SYDNEY METRO CROWS NEST OVER STATION DEVELOPMENT (SSD 9579)

NORTH SYDNEY COUNCIL SUBMISSION

SYDNEY METRO CROWS NEST OVER STATION DEVELOPMENT (SSD 9579)

**Figure 2 – Proposed Crows Nest OSD building envelope (axonometric diagram) and future high-rise development in the St Leonards Town Centre (Sydney Metro’s EIS)**

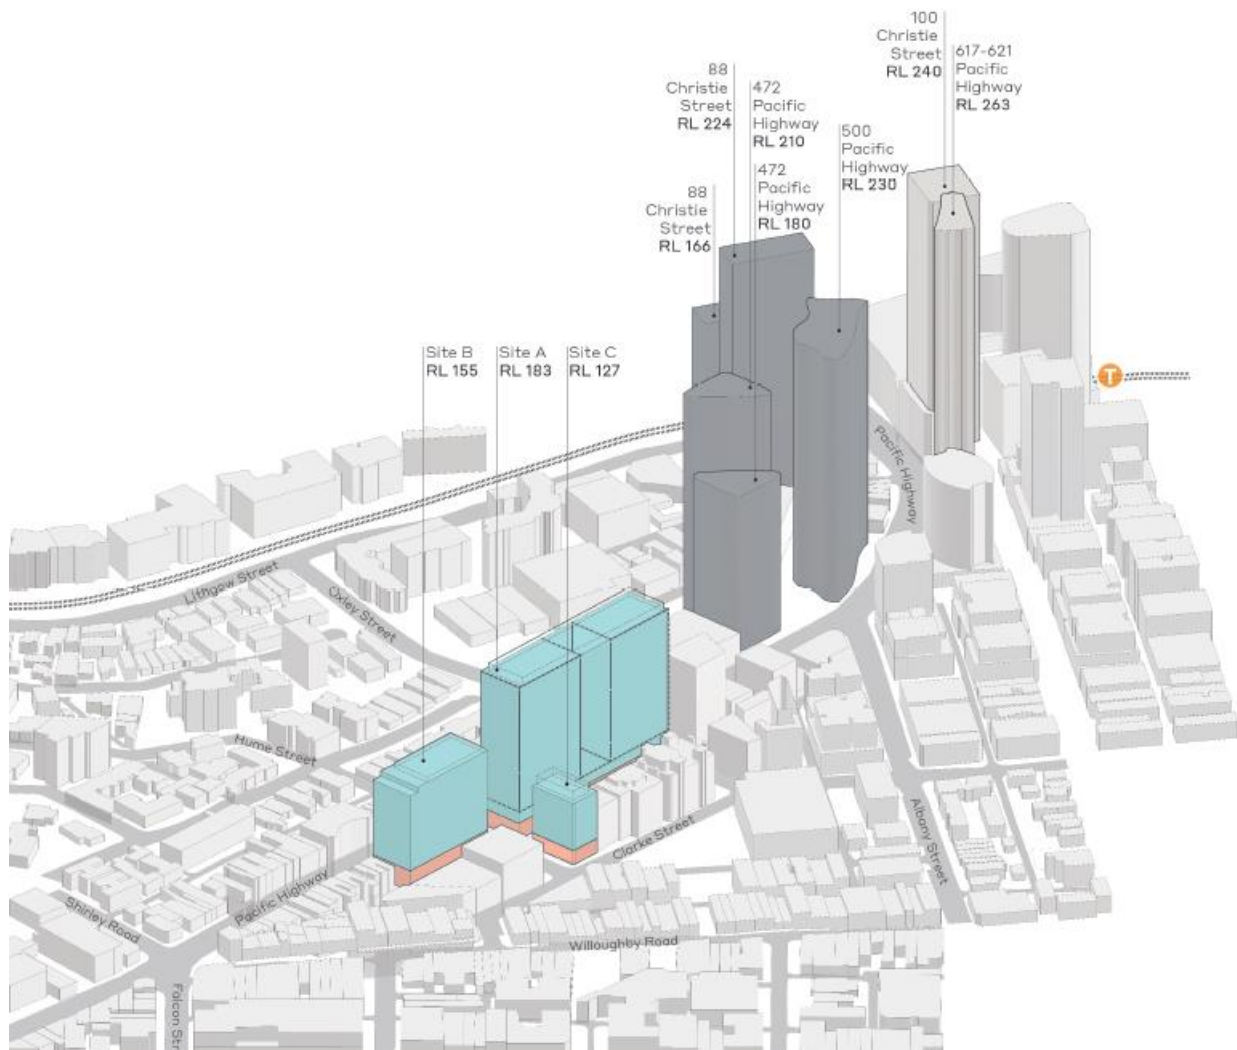
The montages provided in the application appear to be misleading as it includes some buildings that are yet to be approved, other buildings that are incorrectly located and with incorrect proposed building forms, further they are not the future scale of buildings proposed in the, yet to be finalised, 2036 plan.

21st September, 3.45pm

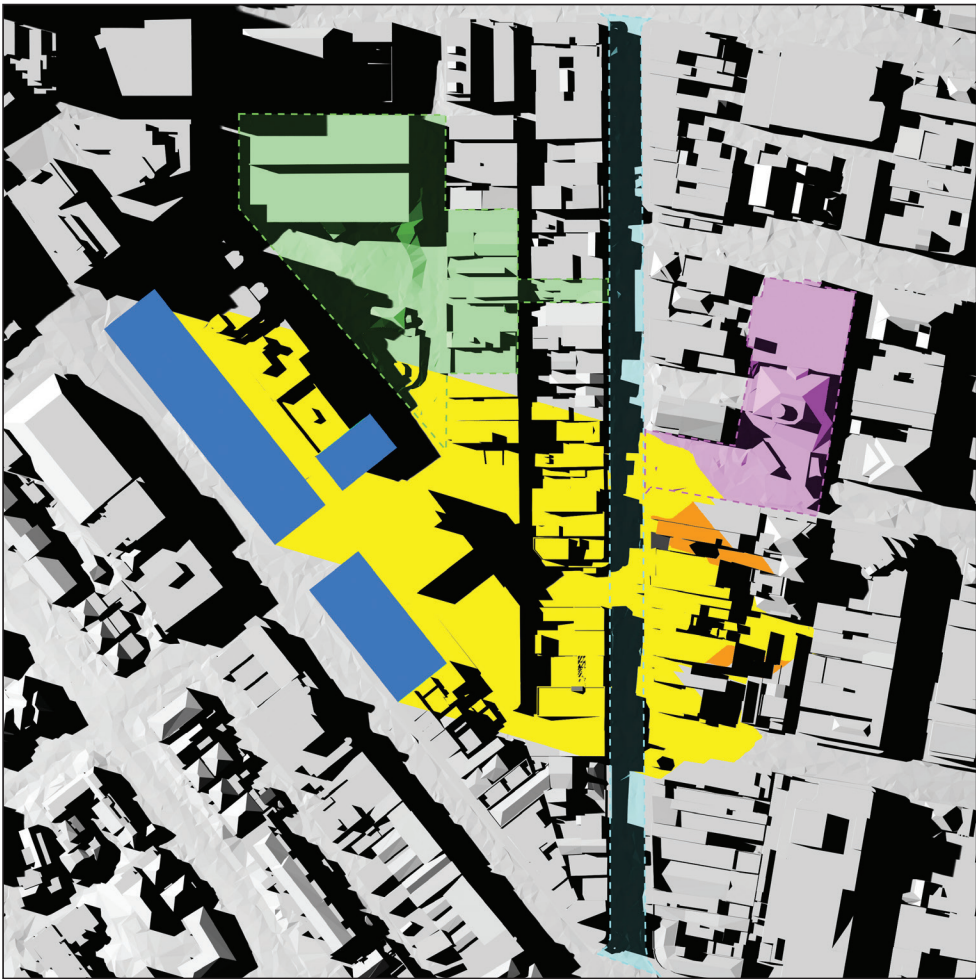
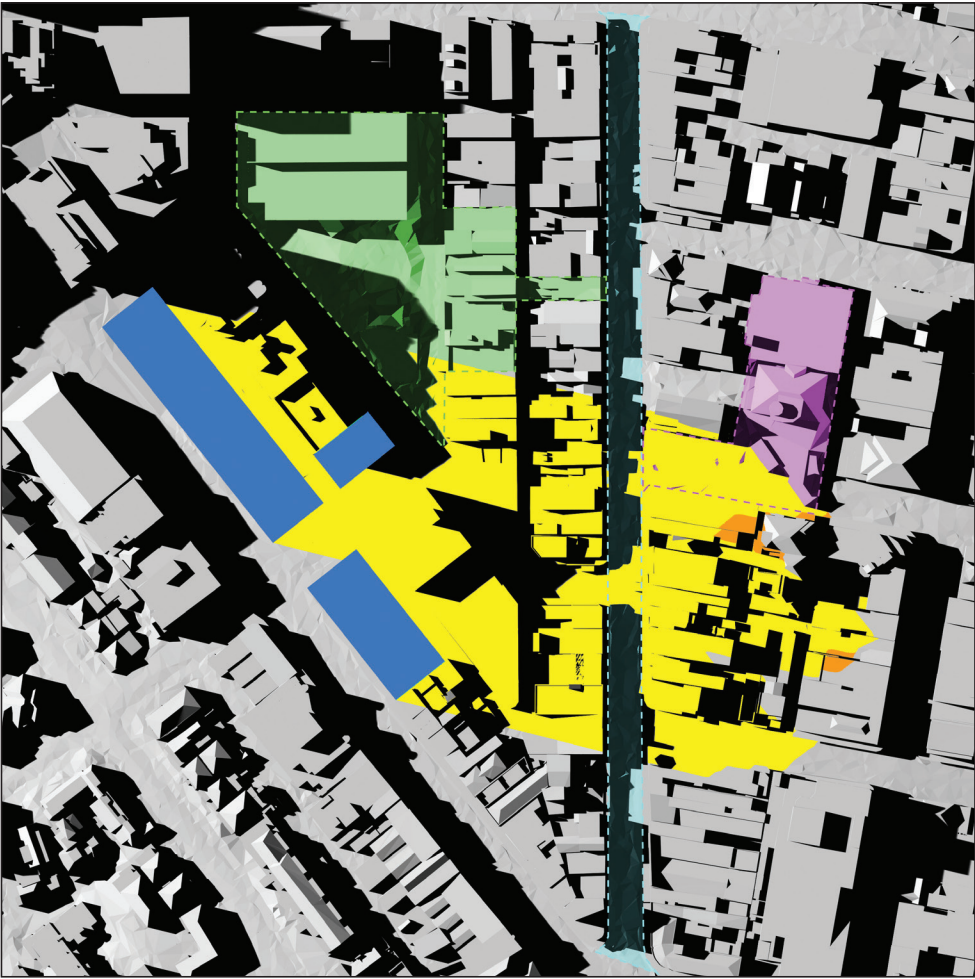
The overshadowing of Ernest Place and Willoughby Road is unacceptable. The parts of the buildings causing the overshadowing need to be identified and modified.
